# Rezoning Transportation Analysis

Petition Number: 2020-038

General Location Identifier: Tax ID 20143102

Date	Description
04-22-2020	First Review
05-19-2020	Second Review

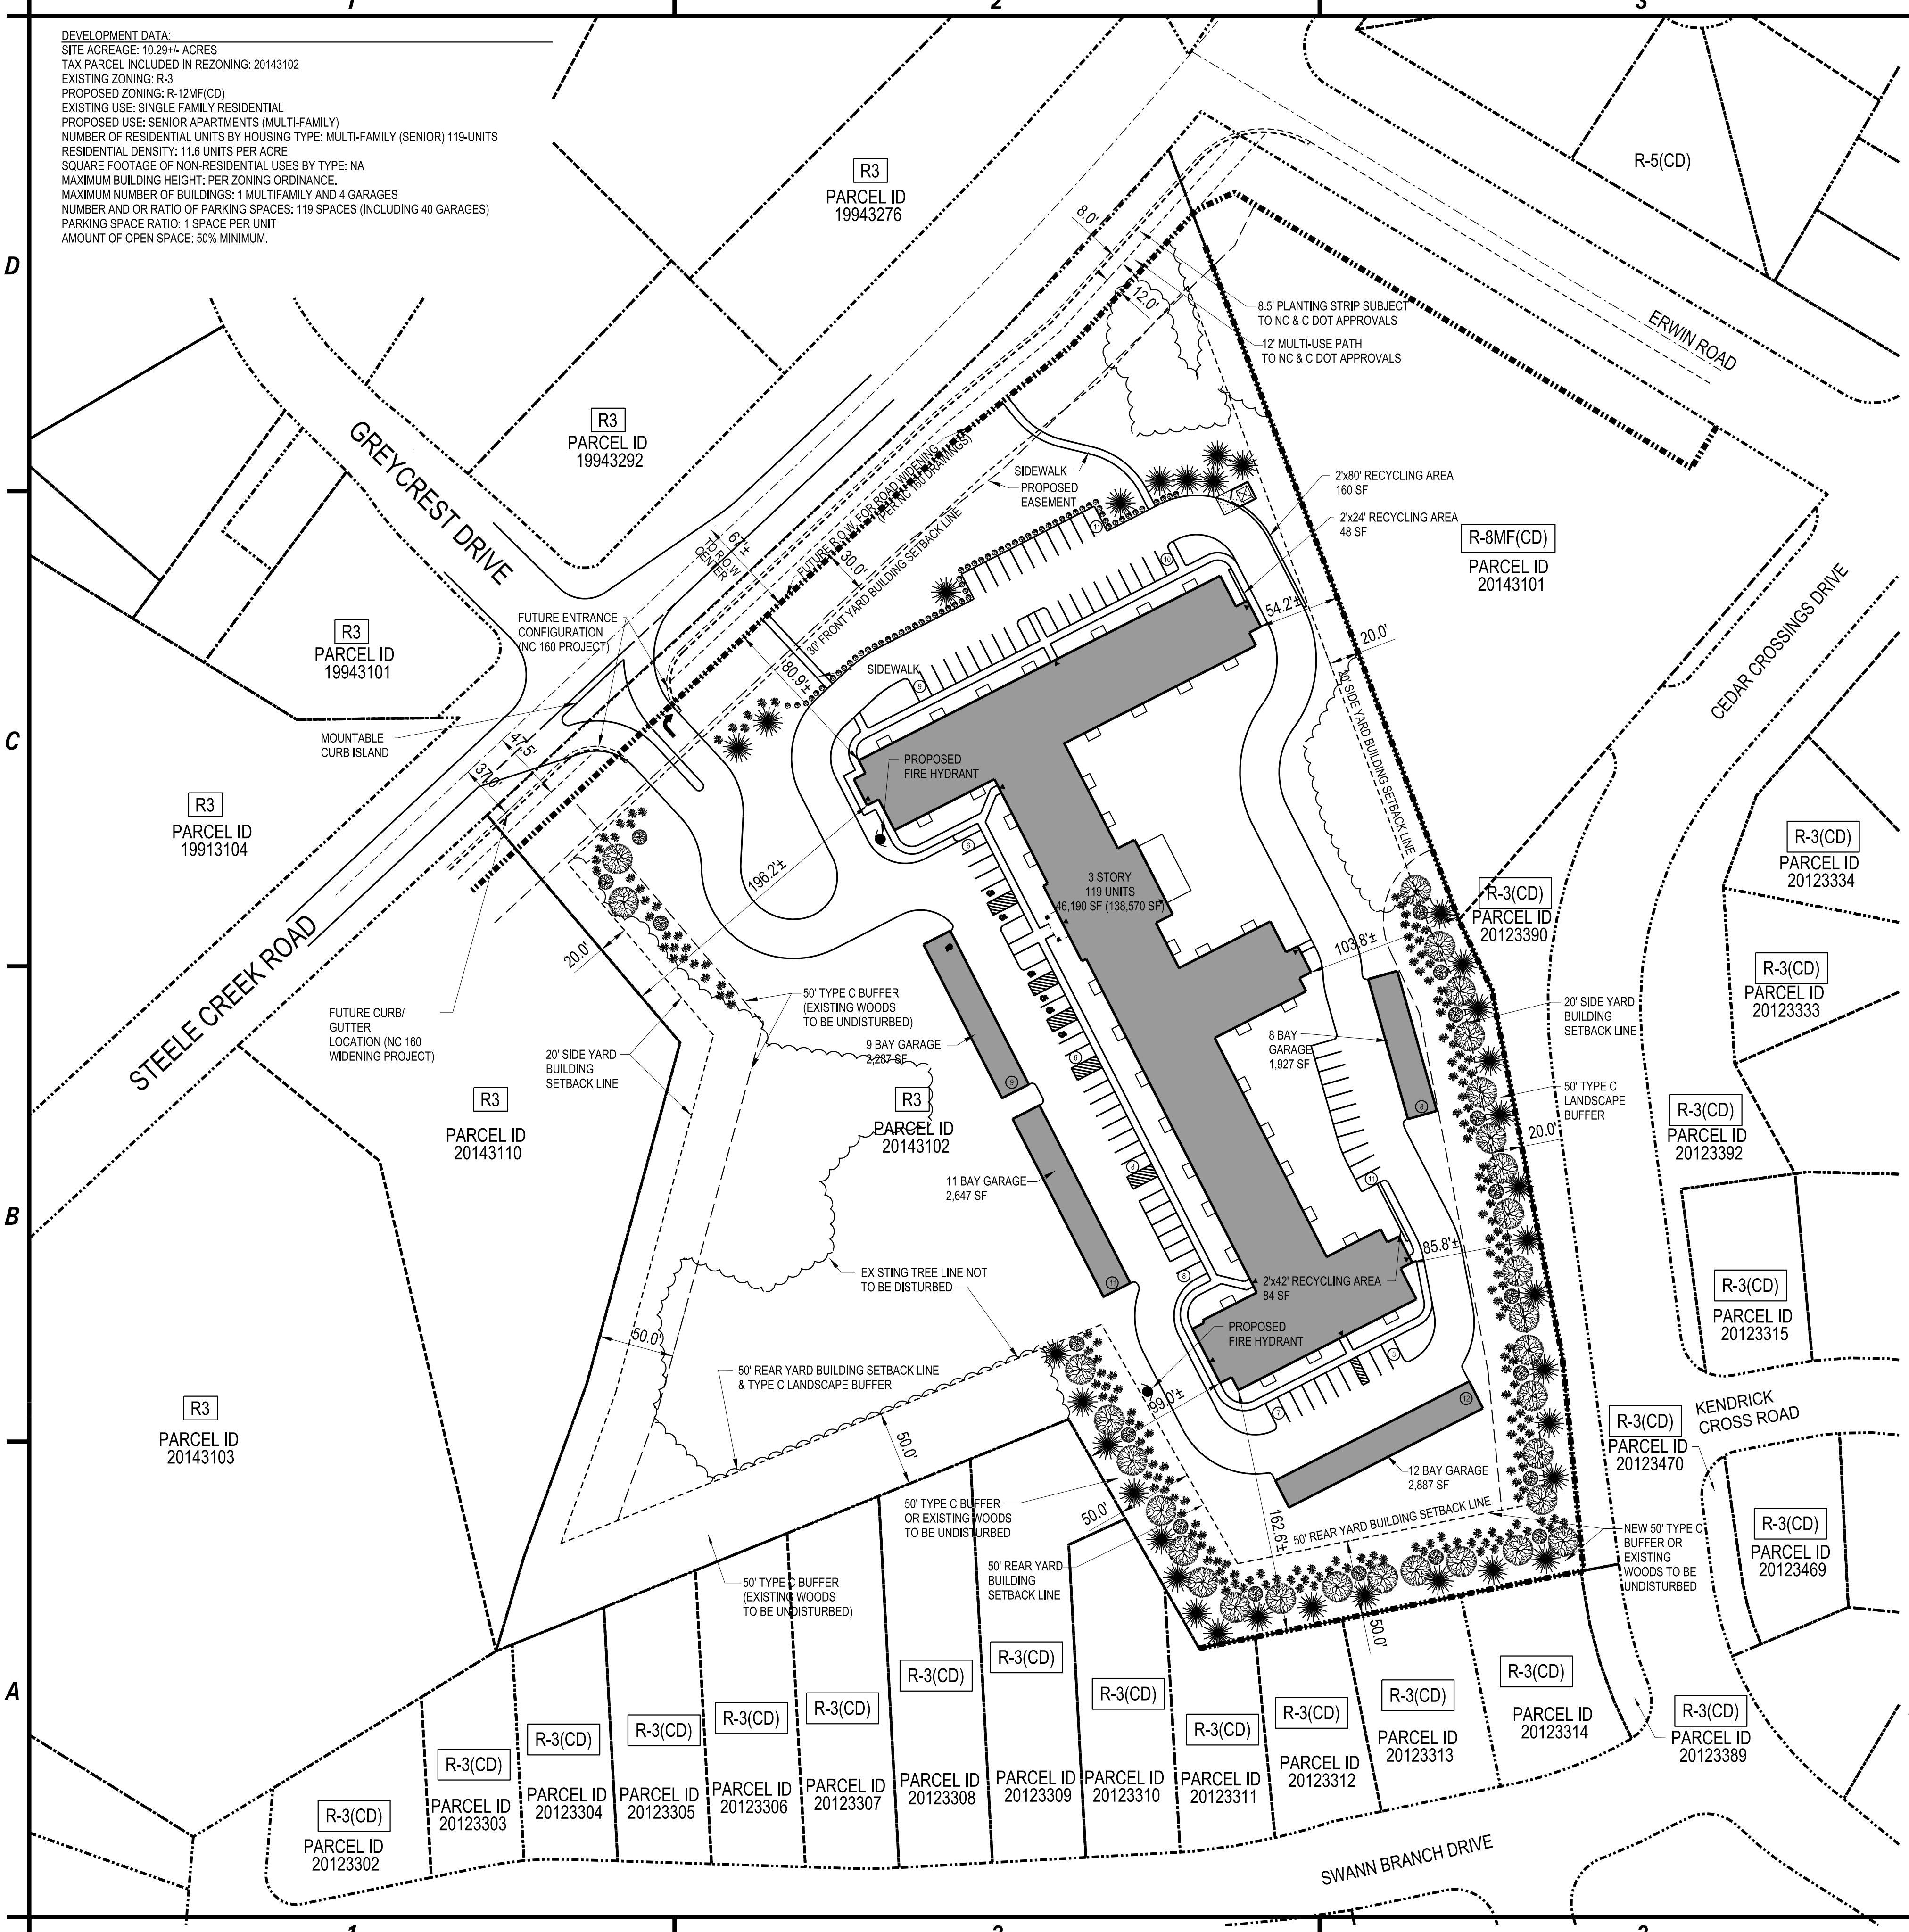
- a. **Steele Creek Road:** Location of curb and gutter needs to be shown on the plans based on the NCDOT TIP Project (U-5766) NC 160. The curb and gutter doesn't need to be constructed, but it does need to be shown on the plans.

The site plan should show the curb and gutter labeled and dimensioned from the centerline for each road.

3. The petitioner should revise the site plan and conditional note(s) to commit to dedicate right-of-way from the road centerline for the NCDOT TIP Project (U-5766) NC 160. You can contact NCDOT for the exact location of the curb and gutter. The site plan should label and dimension the right-of-way from the road centerline.

- a. **New Comment based on revised site plan dated 4-1-2020:** Please review the NC 160 cross section provided below to revise the site plan to include the correct curb line and right-of-way location.

4. The petitioner should revise the site plan and conditional note(s) to commit to a 100' right-turn lane into the NC 160 access point. It is an NCDOT requirement.

5. The petitioner should revise the site plan and conditional note(s) to commit to provide a 50-foot driveway stem from the future NC 160 right-of-way line.

- a. **New Comment based on revised site plan dated 4-1-2020:** Please refer to the cross section below on the NC 160 project's Map 4 at <https://www.ncdot.gov/news/public-meetings/Pages/U-5766-2019-08-21.aspx>. This resource will provide more guidance to

properly revise the driveway stem to provide 50' from the future right-of-way line. The driveway should be perpendicular with the future right-of-way.

6. The petitioner should revise the site plan and conditional note(s) to commit to construct a left-turn lane with 150' of storage and appropriate left-turn lane tapers based on the speed limit.

7. The petitioner should revise the site plan and conditional note(s) to show an exhibit showing full access with left-turn lane, and the future access on NC 160, based on the NCDOT NC 160 widening project. A conditional note should be added that the access will be changed based on the NCDOT project.

8. The petitioner should revise the site plan and conditional note(s) to commit to construct an 8-foot planting strip, and 6-foot sidewalk on Cedar Crossing Drive to meet the Subdivision ordinance. The site plan should label and dimension both items from the back of curb and gutter and road centerline.

9. The petitioner should revise the site plan and conditional note(s) to commit to construct an 8-foot planting strip, and 12-foot multi-use path on Steele Creek Road at its ultimate location. The site plan should label and dimension both items from the back of curb and gutter and road centerline.

10. The petitioner should revise the site plan and conditional note(s) to include an additional access point to Cedar Crossing Drive, as the Subdivision ordinance require two access points for this type of development. The access should be located opposite of Kendrick Crossing Road.

11. The petitioner should revise the site plan and conditional note(s) to include a sidewalk connection from the site to the sidewalk along Cedar Crossing Drive.
